Please discuss DP1 and compare the runoff leaving the site under existing and proposed conditions.

SILVERADO RANCH

MASTER DEVELOPMENT DRAINAGE PLAN

DEVELOPED DRAINAGE PLAN

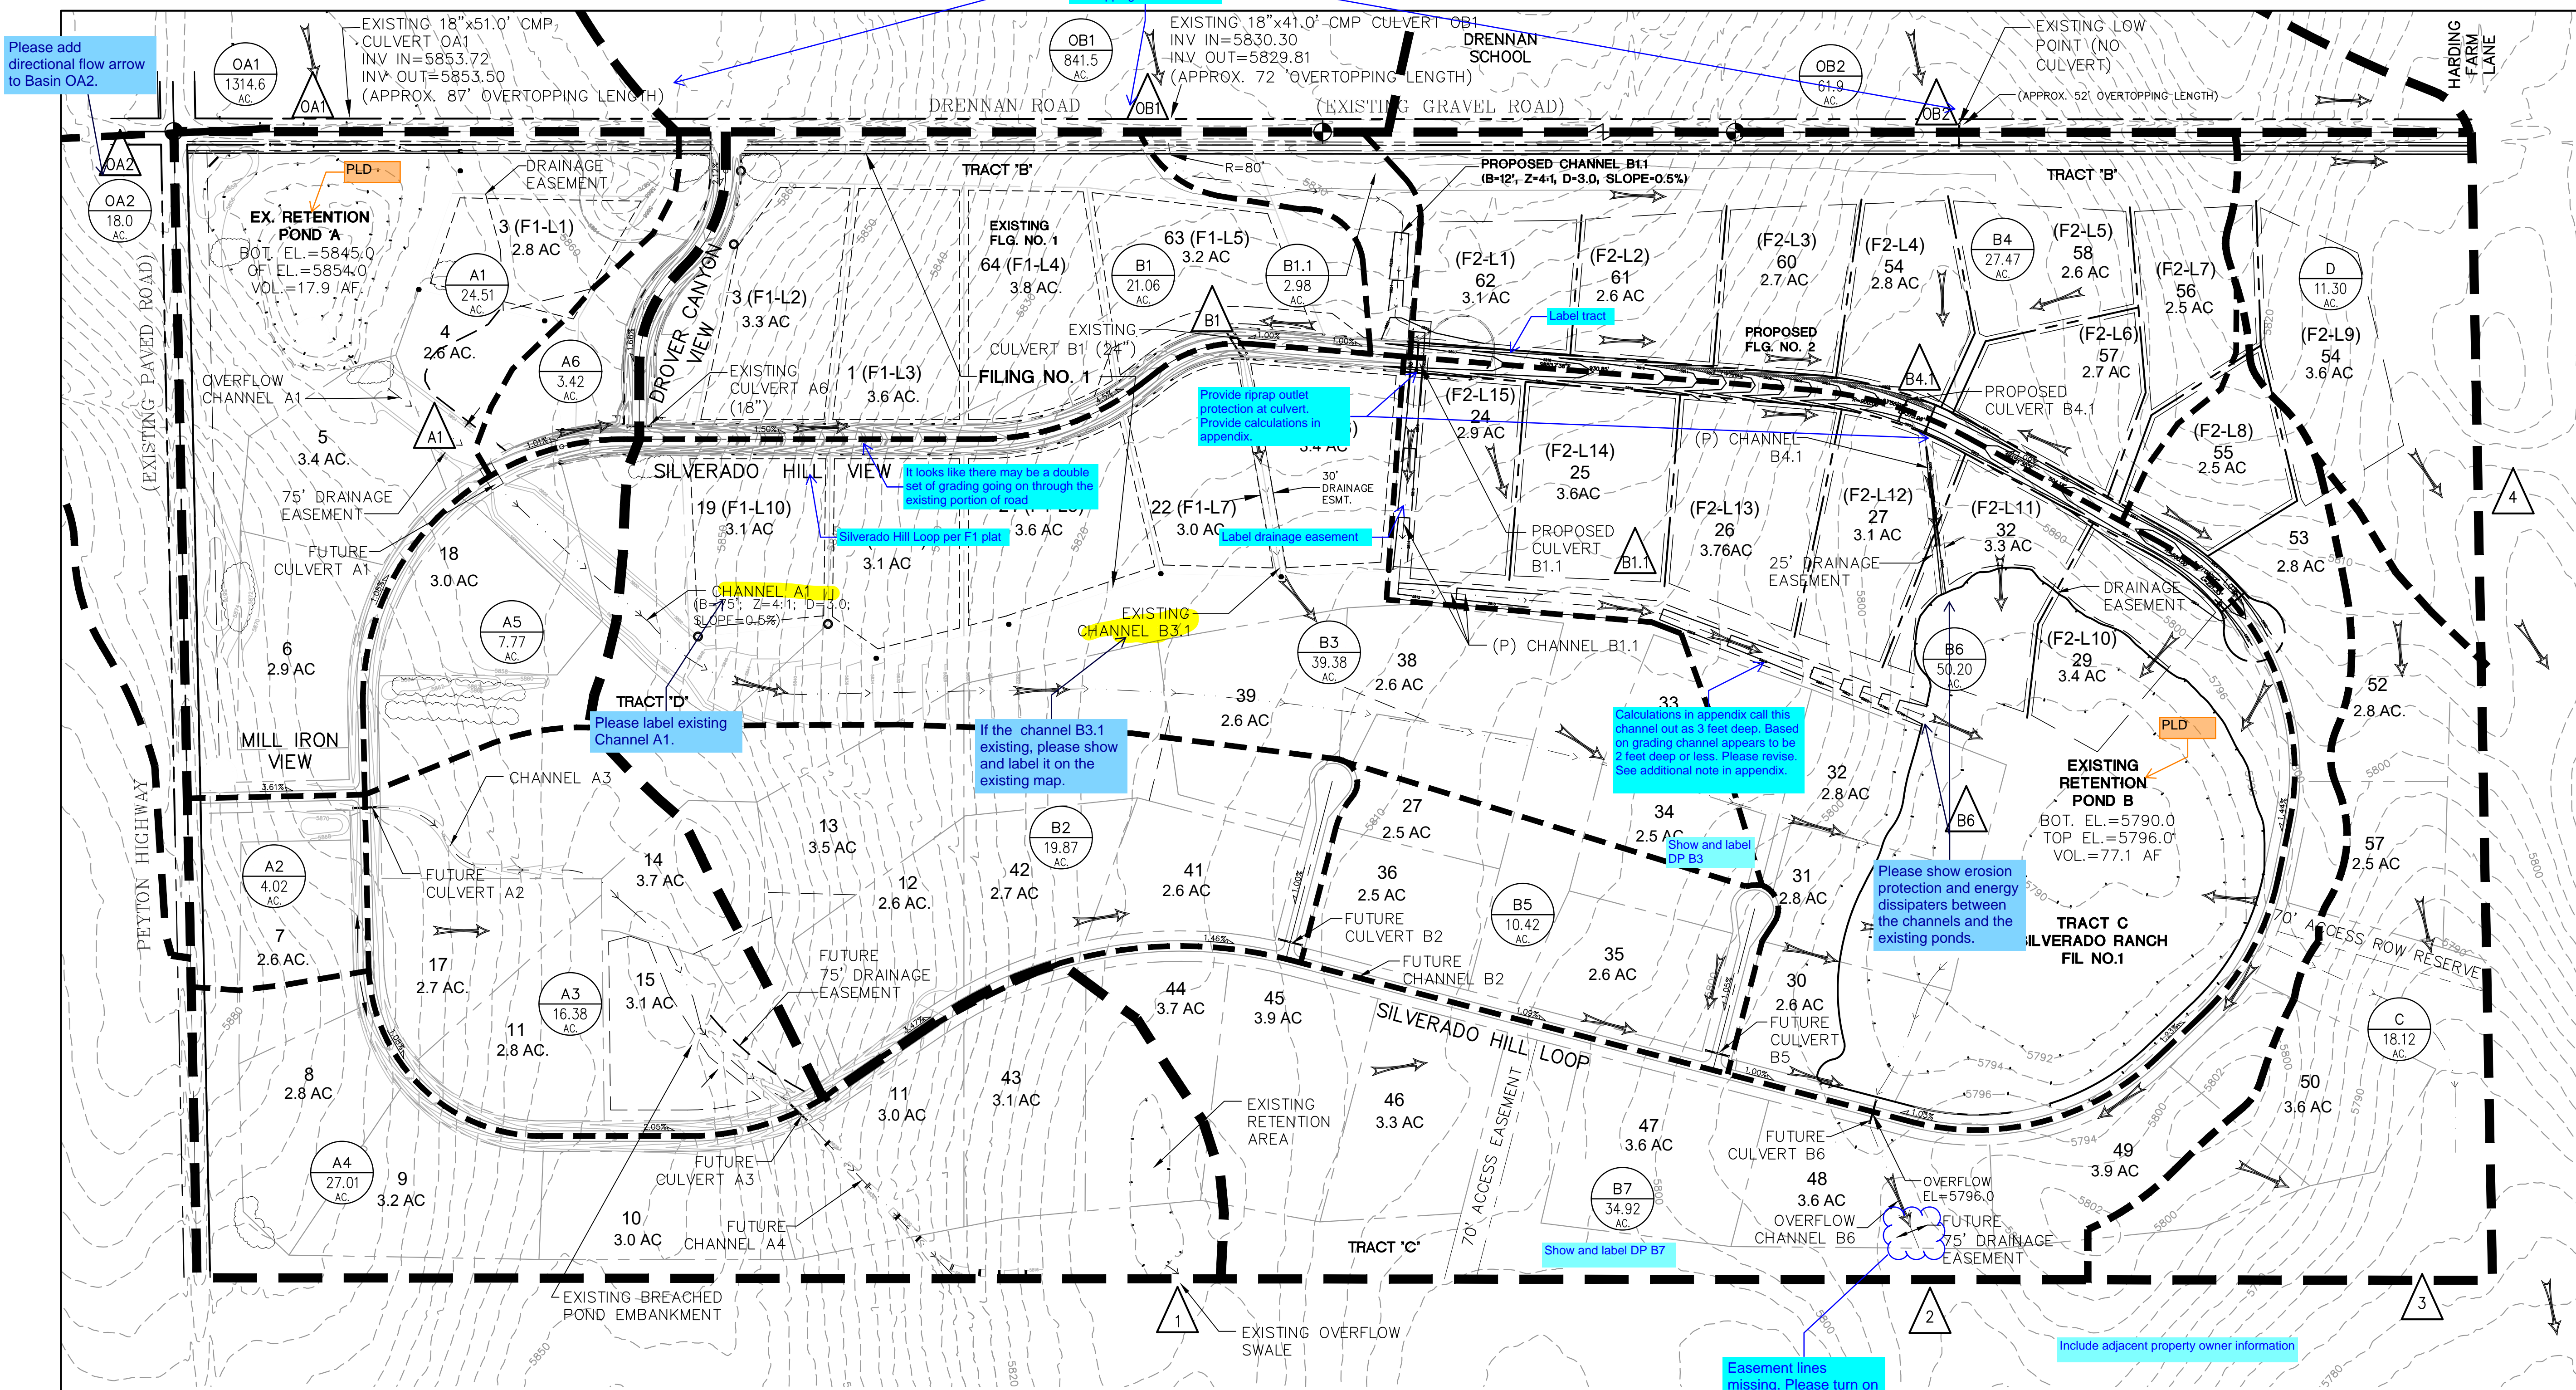
Proposed runoff at DP1 exceeds the existing runoff significantly. Please discuss on the safe management of this increased runoff.

Review C1: Turn off future improvements. If you want this information left in the report, refer to it as an "ultimate condition" map. Need to have proposed drainage map showing only existing and proposed conditions. Revise any drainage basins and routing as needed for this condition.

Review C2: Unresolved.

OVERFLOW
Please show and label the emergency spillway of existing Pond A, ensuring it meets current criteria. Include calculations if proposing or upgrading.

Review C1: Please show erosion protection and energy dissipaters between the channels and the existing ponds
Review C2: Unresolved. Please call out permanent check dam and erosion protection at each inflow point. Please see comment in the text.

Review C2: Unresolved. Please call out permanent check dam and erosion protection at each inflow point. Please see comment in the text.

Please upgrade the emergency spillway of the existing pond to meet the current criteria. Calculation is required.

The flow from DP2 is concentrated and during minor storms, it exceeds existing conditions. Please provide erosion protection. Additionally, how can this concentrated flow downstream be mitigated?

Review C1: List all storm facilities/structures as public or private

Review C2: Unresolved.

Review C1: Easement lines missing. Please turn on
Review C2: Unresolved.

Added permanent Rock Check Dam and Riprap Apron call outs at each inflow point

Sh. D1.2: Filing 2 Developed Drainage Plan was previously added in response to this comment: Title for this sheet has been updated to "Ultimate Conditions; For Reference Only"

These comments will be addressed with the applicable future phase; this area will not be disturbed during Filing No. 2

This comment was addressed by adding a note at bottom of Sh. D1.2 stating "All Proposed Storm Facilities Are Private (HOA-Maintained)"
